NORTH FALLS

Offshore Wind Farm

Applicant's Response to Natural England's Deadline 3 submissions

Document Reference:	9.43
Volume:	9
Date:	April 2025
Revision:	0

Figure 4-1 Indicative decision tree for Bentonite clean up

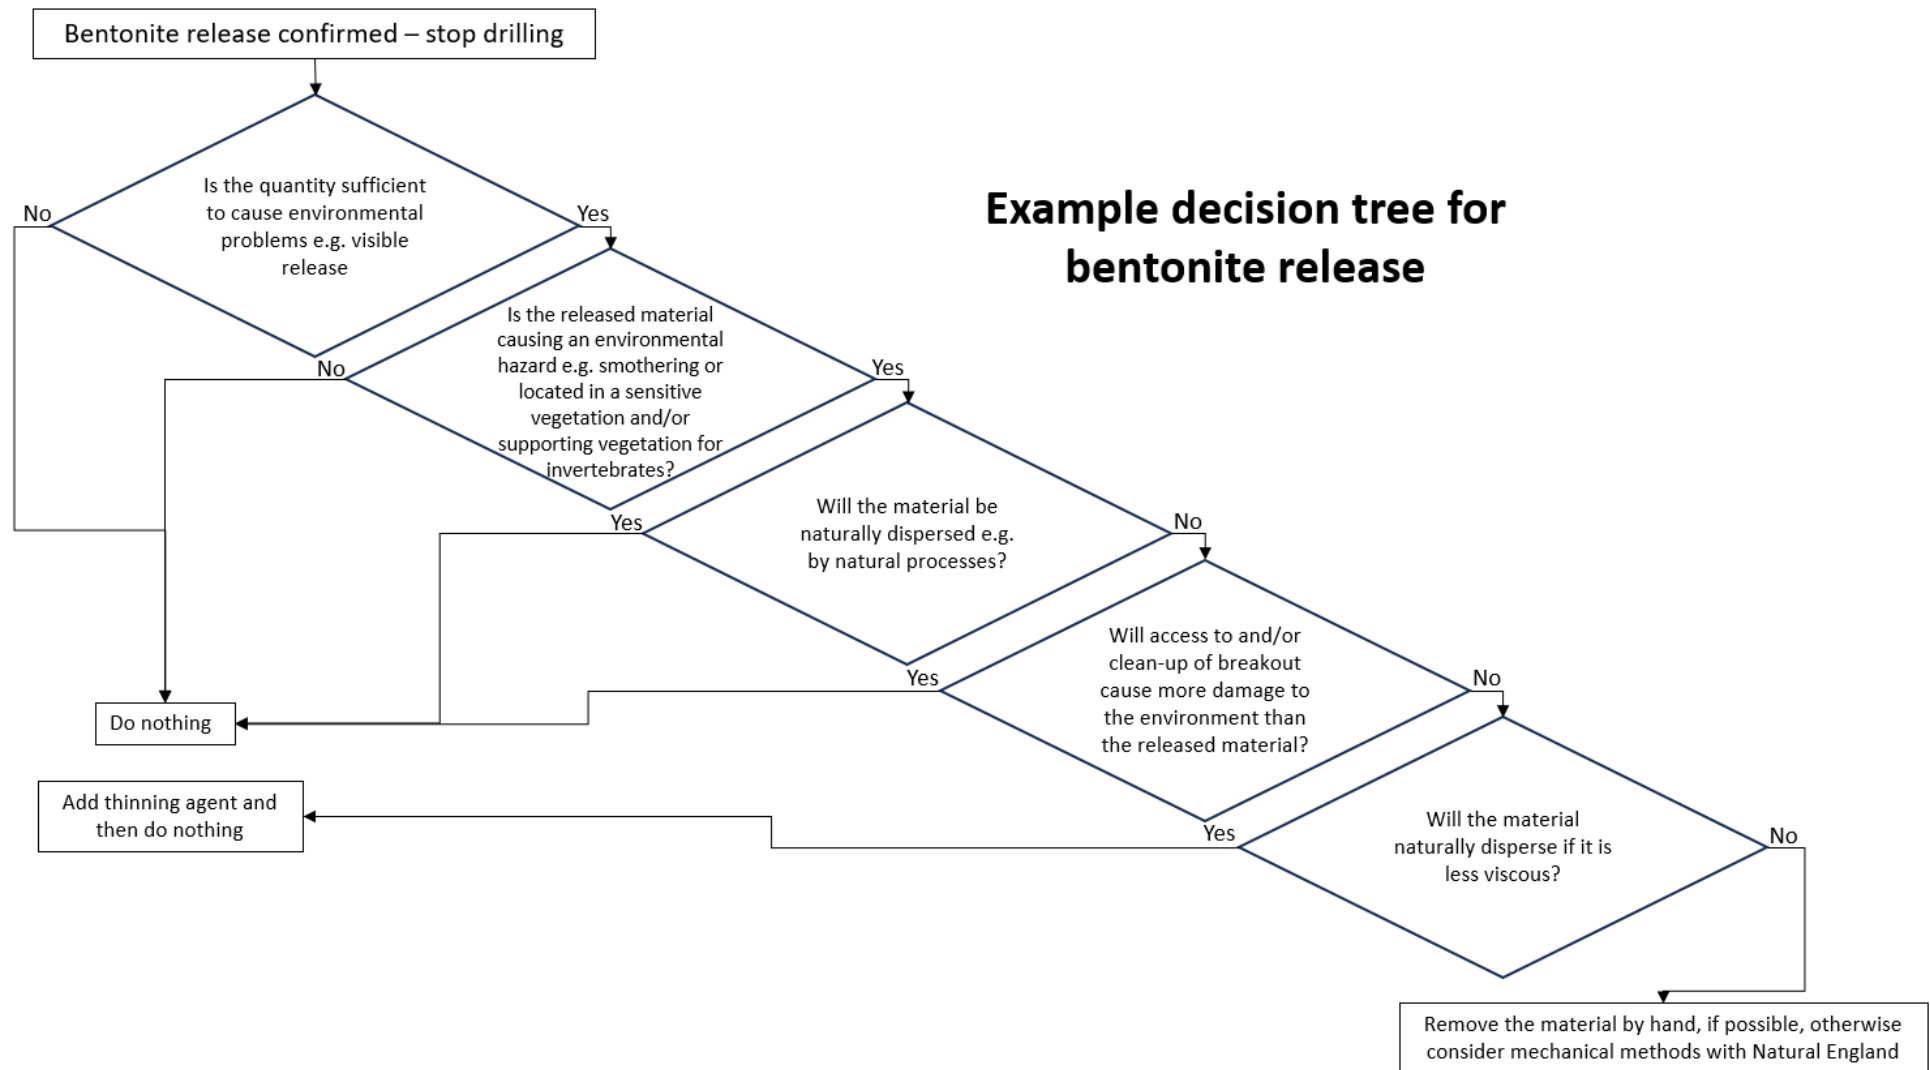
REP3-063_c	Natural England notes that within the flow chart there is a step missing to determine if clean-up and/or containment is required. We advise that just because there is a visible leak, this shouldn't automatically lead to either of these things occurring given the inert nature of the bentonite. Natural England highlights that the area of spill is not the key detrimental factor, but more the potential depth of any smothering especially where there are sensitive environmental receptors.	Natural England advises that the decision tree is refined to help with making any decisions on the course of action to be taken. Please see following points.	Noted. The Applicant will amend Step 1 (<i>'Is the quantity sufficient to cause environmental problems? (e.g. visible release?)'</i>) into two steps, the first being 'Is there a visible release?' (leading to 'Do nothing' or further steps), followed by a second step 'Is the quantity sufficient to cause environmental issues (to watercourses, or to sensitive ecological receptors)?' (leading to 'Do nothing' or further steps). The Applicant will consult with Natural England before submitting an updated version of the Outline Horizontal Directional Drill Method Statement and Contingency Plan (Rev2) containing this amendment at Deadline 5.

REP3-063_e	Natural England notes that there is no inclusion of roles and responsibilities for implementing the decision tree. And how consultation with the relevant SNCB will be factored in, when and how.	Natural England advises that more information on roles and responsibilities are included to ensure that the environment is safe guarded.	The Applicant will update the example decision tree for bentonite release in the Outline Horizontal Directional Drill Method Statement and Contingency Plan [REP1-037] to include further detail on relevant roles and responsibilities for implementing the decision tree actions. The Applicant will consult with Natural England before submitting an updated version of the Outline Horizontal Directional Drill Method Statement and Contingency Plan (Rev2) containing these amendments at Deadline 5.
REP3-063_f	Entry Pits: Natural England notes that bentonite is most likely to occur in the first 30m of HDD. And that further mitigation measures could be employed to minimise potential impacts to area of nature conservation.	Natural England advises that entry pits, and where appropriate exit pits are located >30m away from any sensitive environmental receptors.	Noted. The Applicant will review the feasibility of this constraint, and will consult with Natural England further on this point, if appropriate. The Applicant will provide an update on this in the updated version of the Outline Horizontal Directional Drill Method Statement and Contingency Plan (Rev2) to be submitted at Deadline 5.
